Application no: H05/0088/99

Location: Cheshire Home
Hovenden House
Lowgate
Fleet

Amendment: Roof light revised
Drawing No. 02541-509A

TOWN AND COUNTRY PLANNING ACT 1990
NOTICE OF ACCEPTANCE OF AMENDMENT

Drawing N° 02541-509A

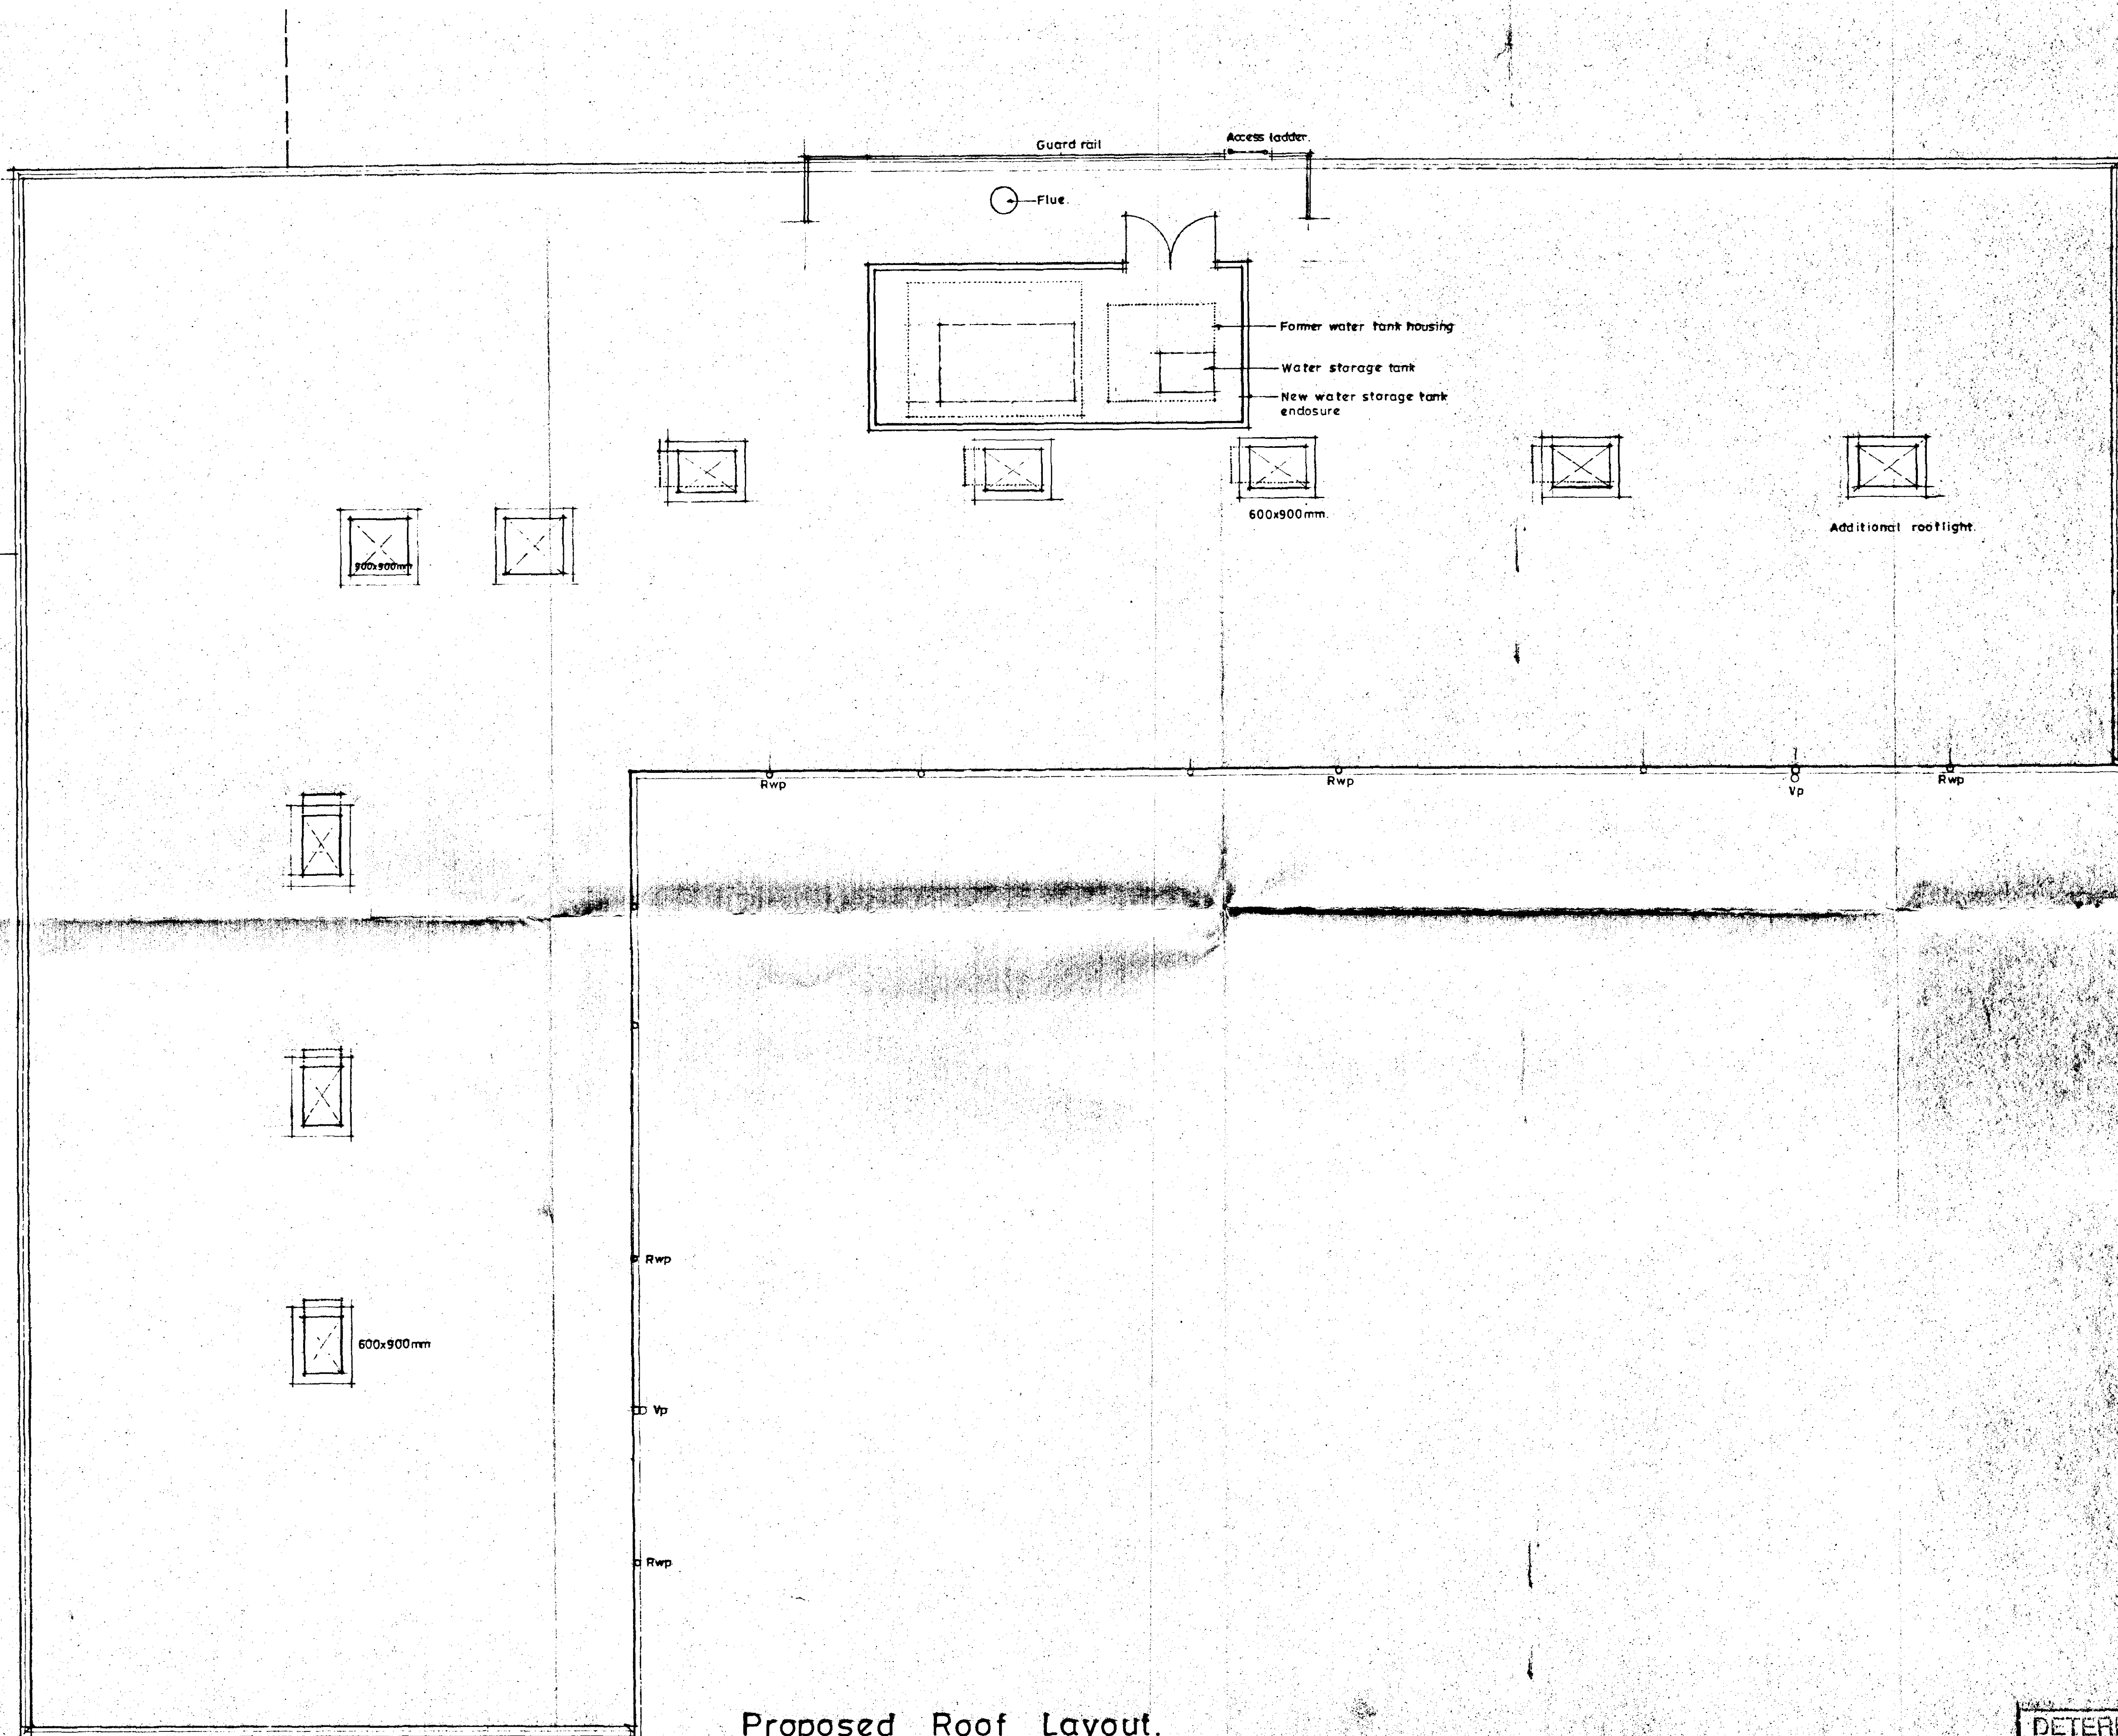
Roof Light Reversed
